## DEVELOPMENT FACILITATION TEAM

### Planning - Case Comments

**Project Number:** PR-2023-009368

**Project Name:** Farolito Senior Community

A1 PLANTING PLAN
1" = 20'-0"

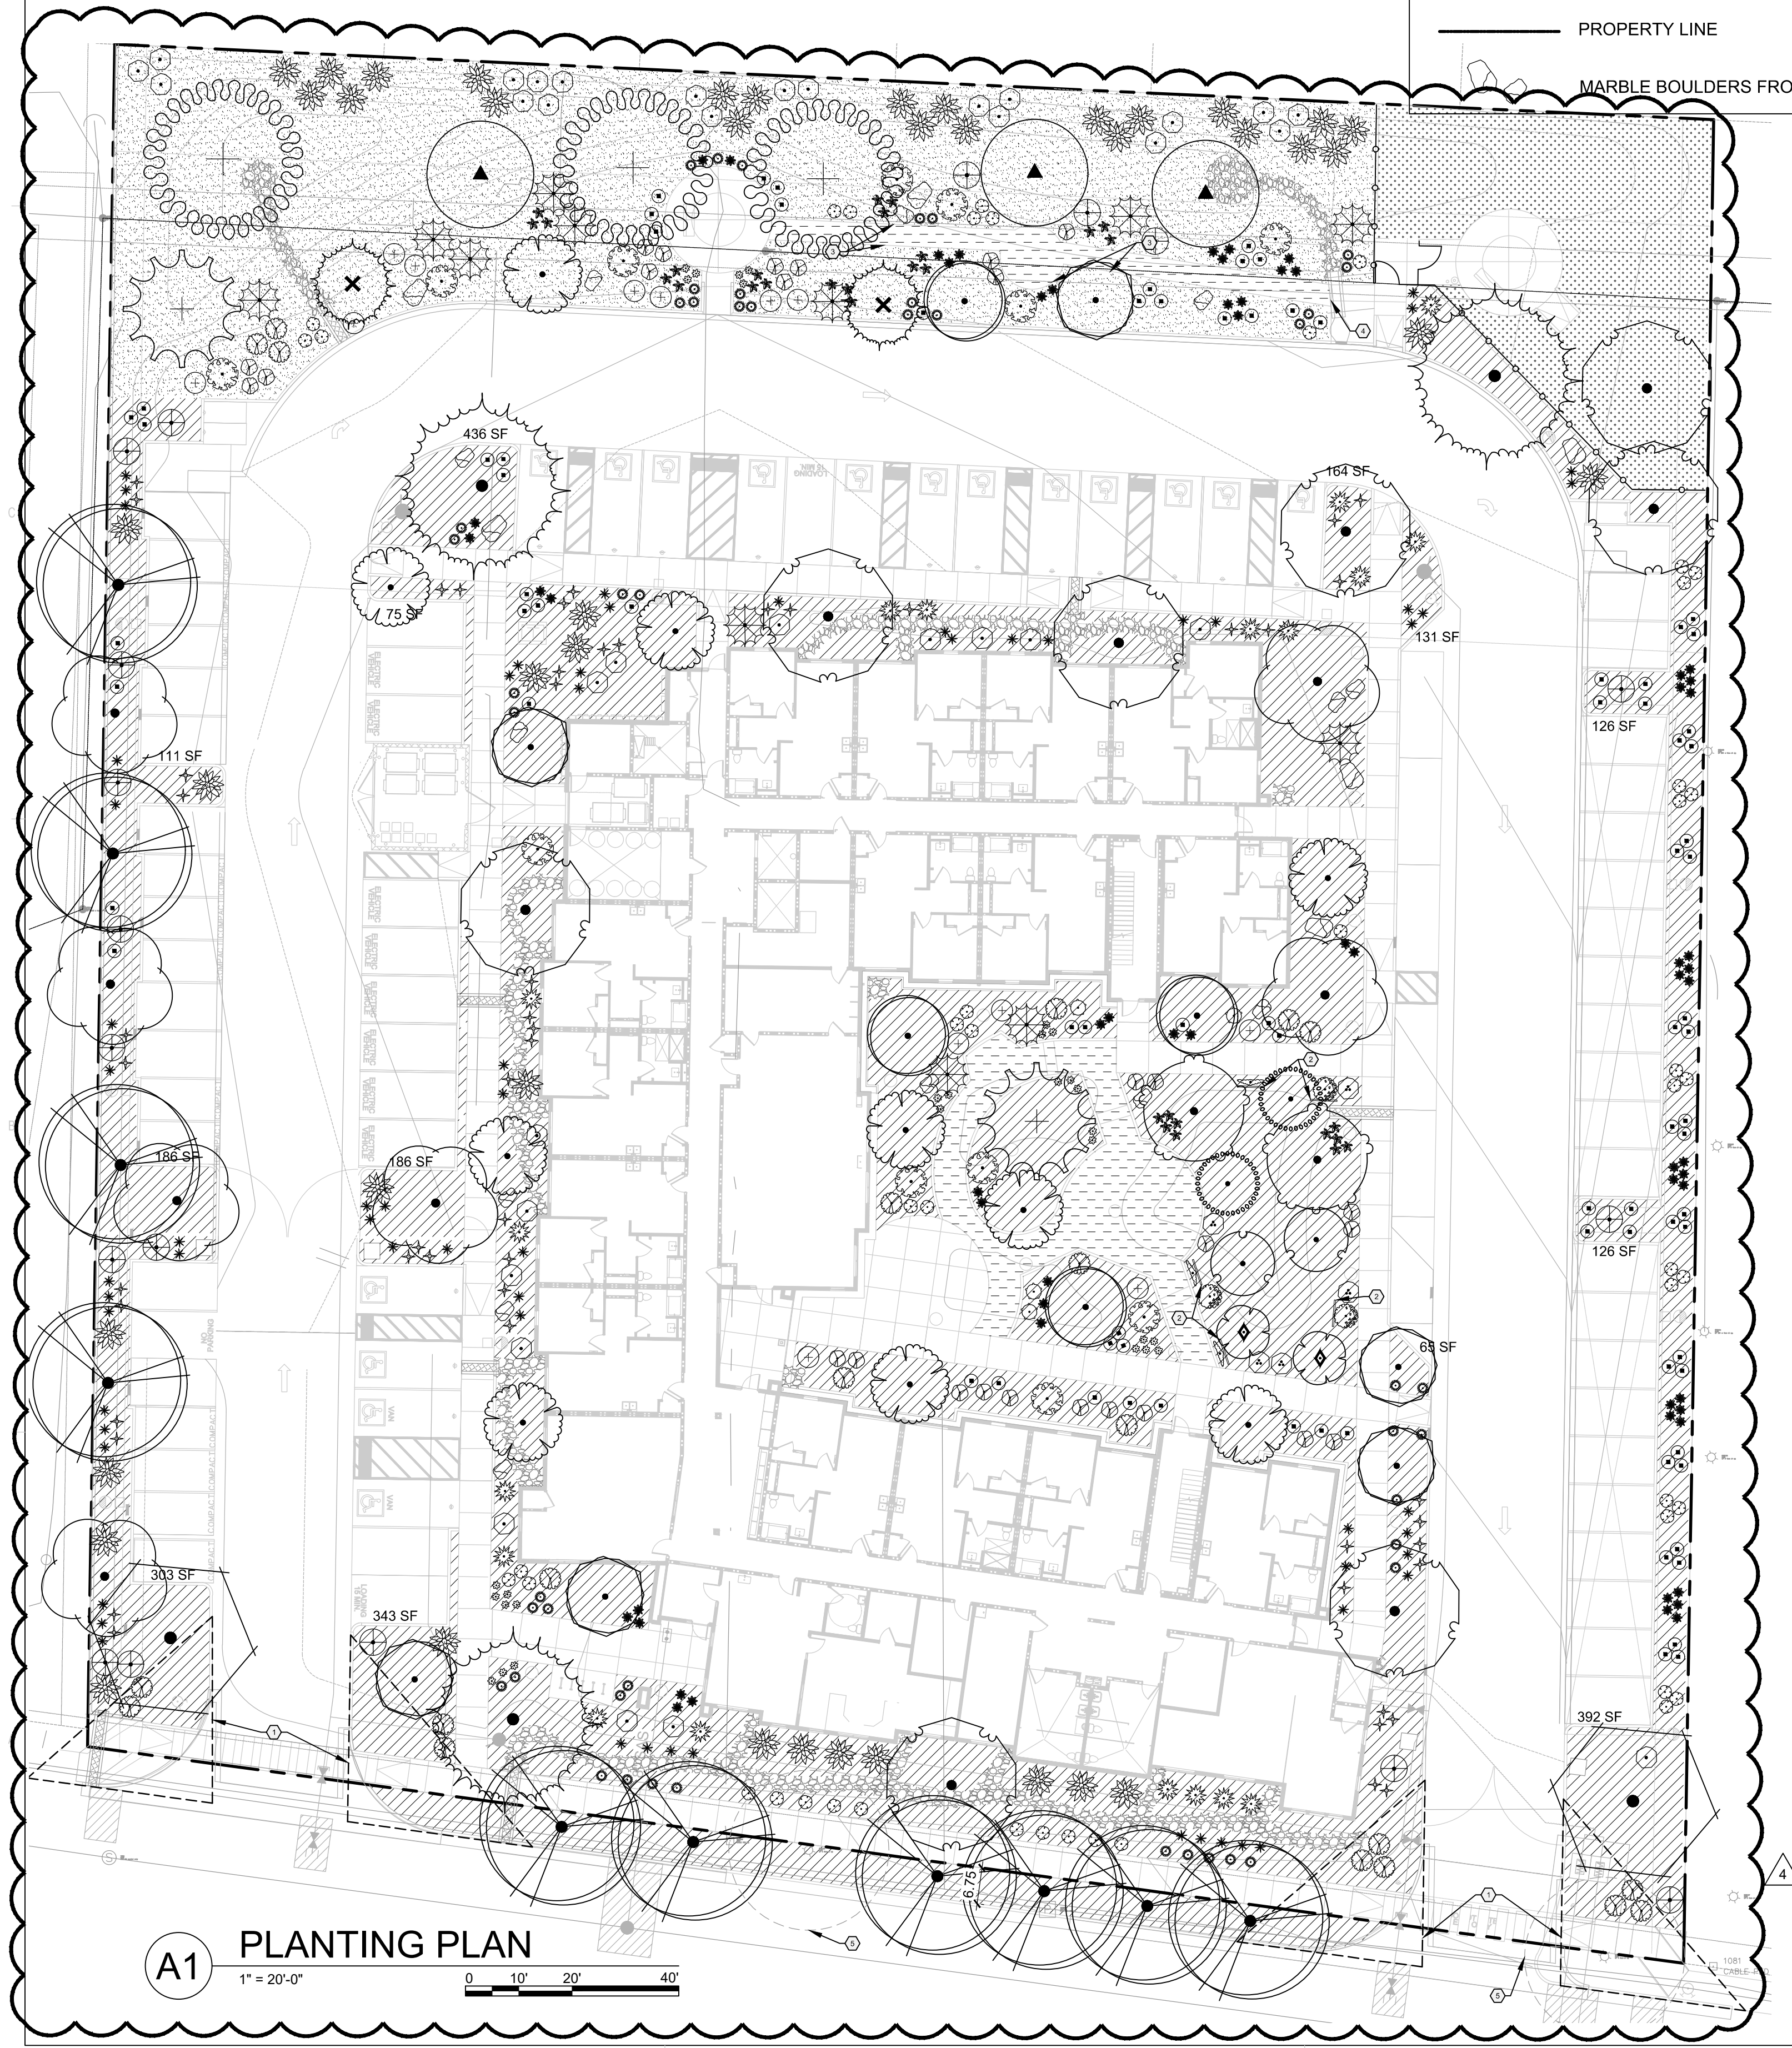
**-Repalce the Raywood ash with Urbanite Ash, Autumn Blaze maple with Bigtooth maple, and Austrian Black pine with Italian Stone pine.** Addressed-DPS.

**-Change the trees under the overhead distribution line along the north edge of the project to Golden rain trees and Russian hawthorns.** Addressed, planting was arranged to meet new plant sizes.

**-Of the two different locust trees you have proposed, choose one type only and spread them in the site so no two locust trees are adjacent to one another, because of the appearance of the beetle that has been killing locust trees.** Addressed, all Locusts are now Purple Robe Locusts, none are next to each other- DPS.

**-Please be aware that Purple Robe locust requires structural pruning. Also, fruit trees are prone to frost damage (especially fig trees). Please add a comment to reflect that if any of the proposed trees die off at any time, they will be replaced with new ones.**  
**-If you have any questions regarding these comments, please contact Bonnie Strange, Senior Planner at the Urban Forestry at [bstrange@cabq.gov](mailto:bstrange@cabq.gov).**

A general note was added to address the locusts, as for the fruit trees, this client specifically requested an orchard on the property for their residents. They have prepared for the proper care and maintenance required. A general note was included for this -DPS

PLANTING DETAILS

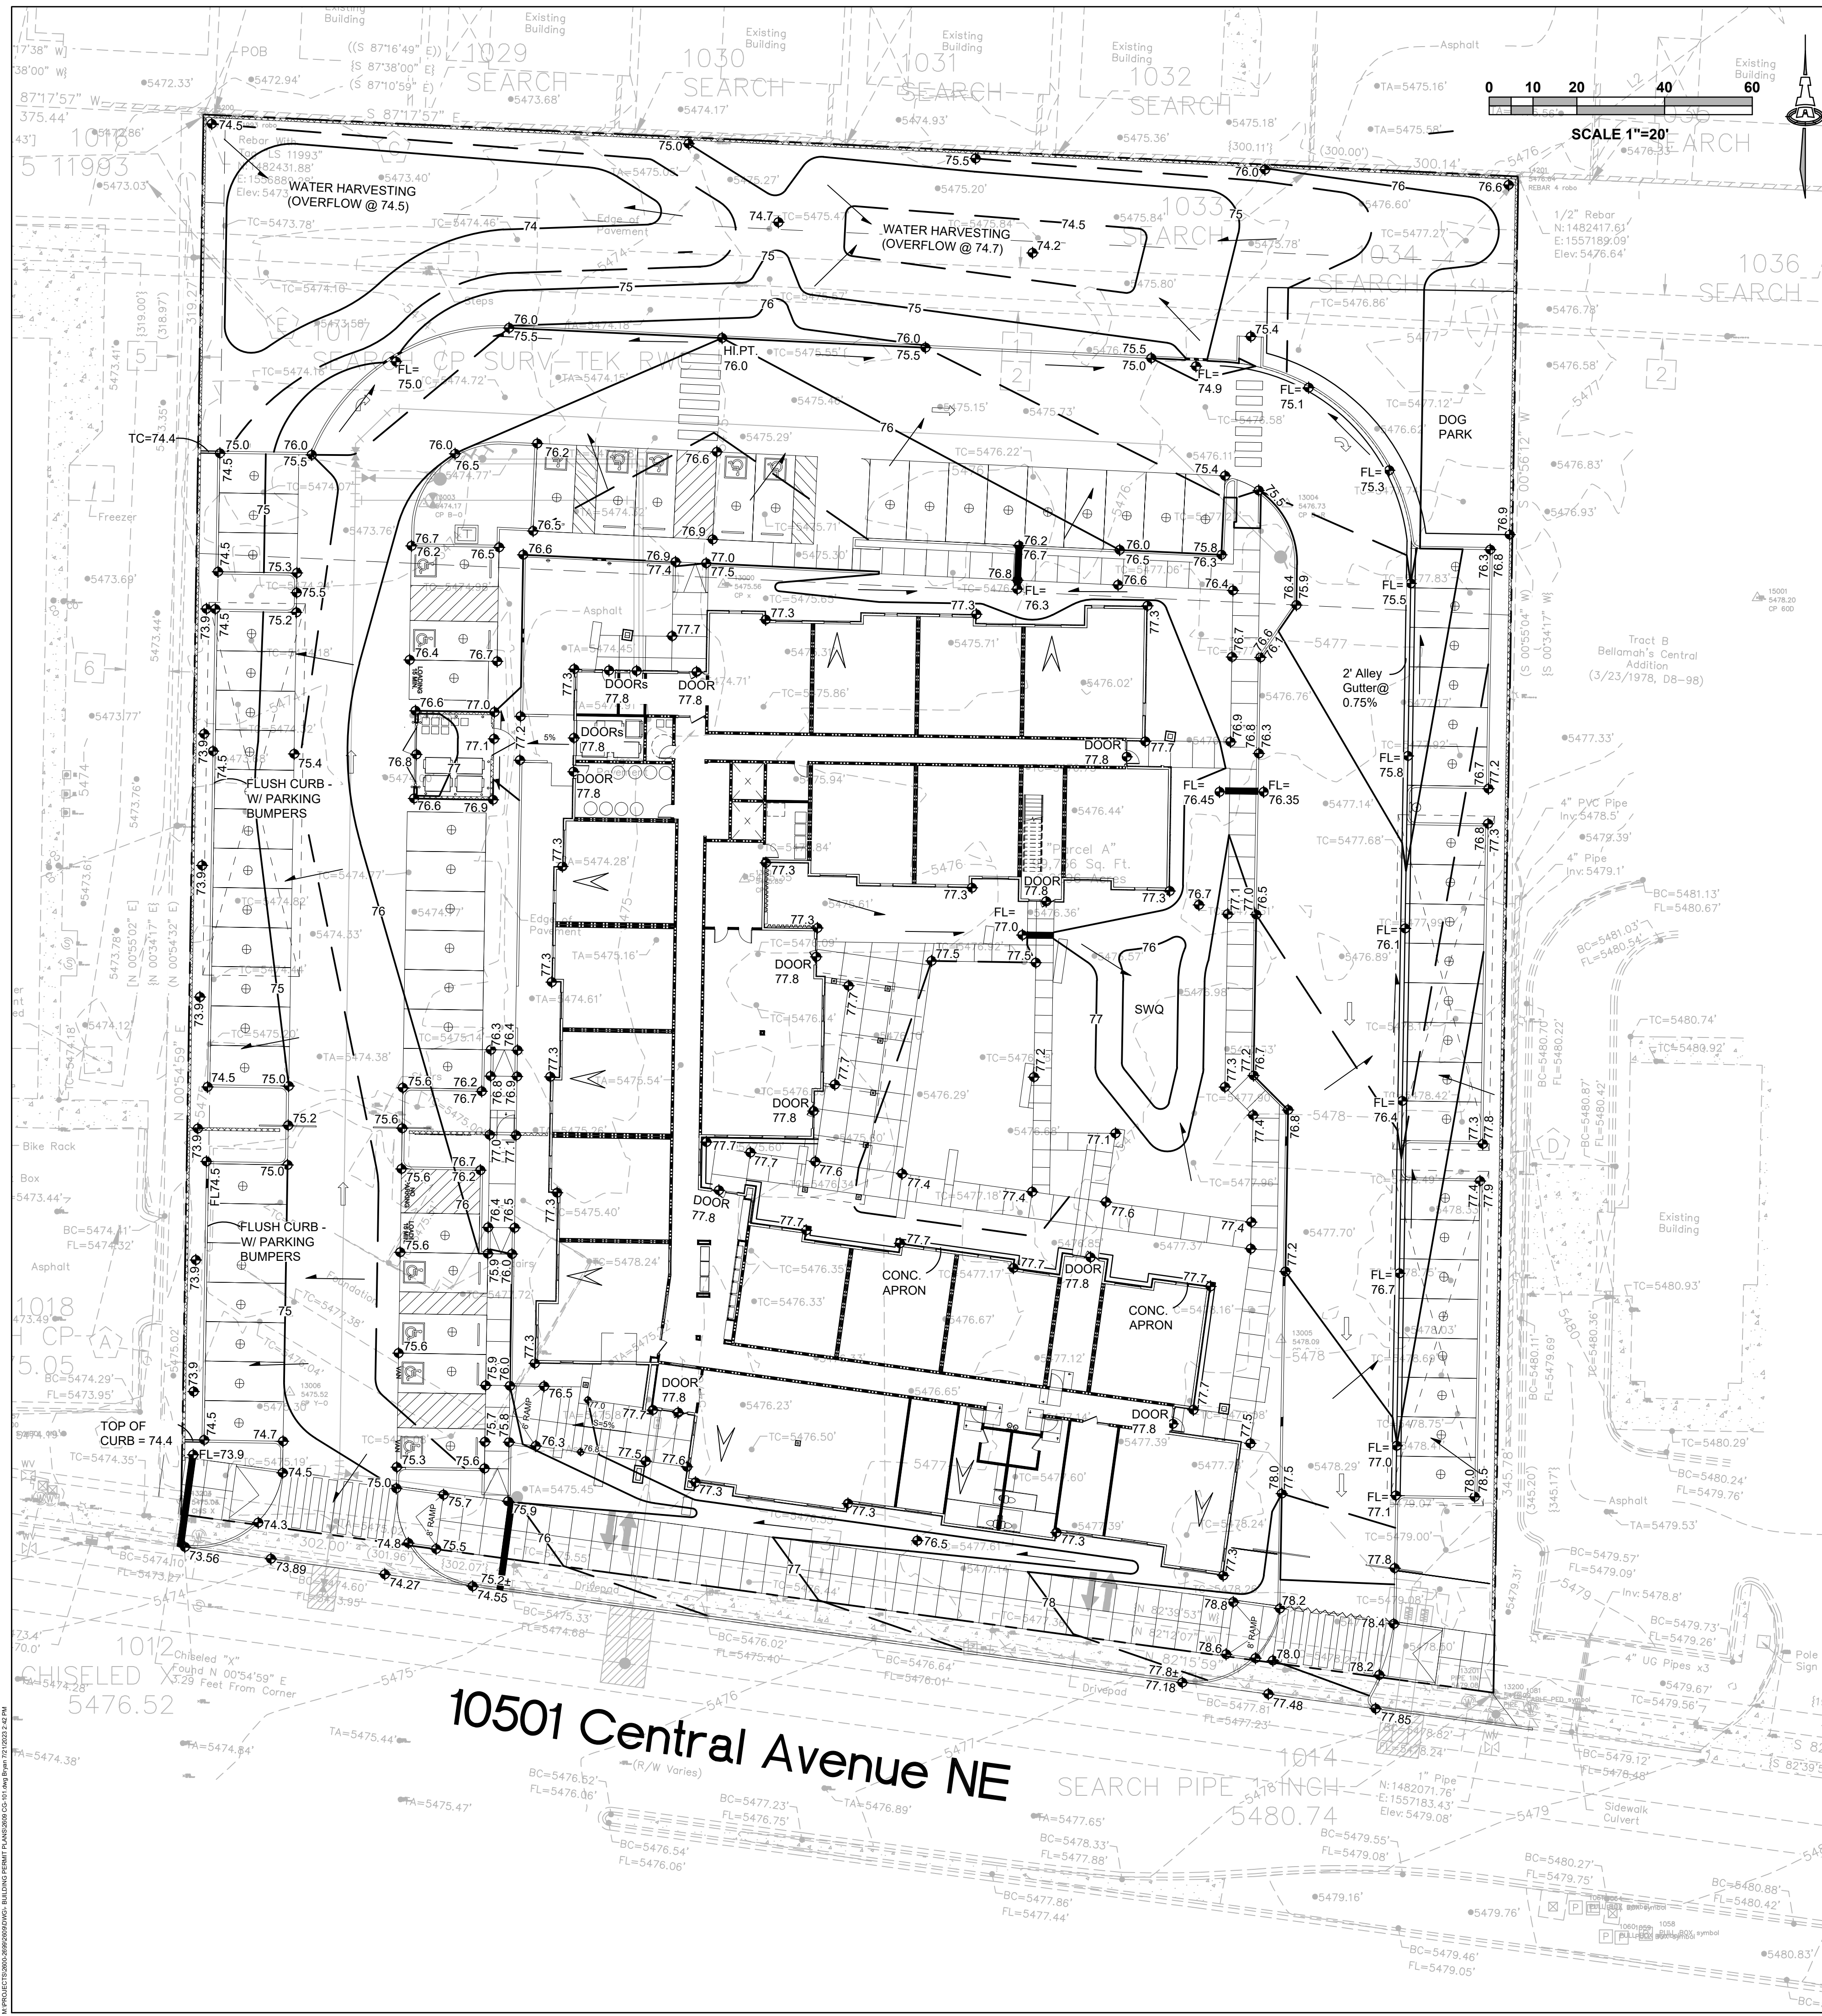
- Per 5-6(C)(5)(e) Organic mulch is required as ground cover under trees within a 5-foot radius around the tree trunk, but not directly against the trunk. In these areas, weed barrier fabric is prohibited. **Please show a 5-foot radius dimension line on the tree planting detail. Please correct the term bark mulch and change it to organic mulch.**

**Addressed, please see updated detail on LP101**
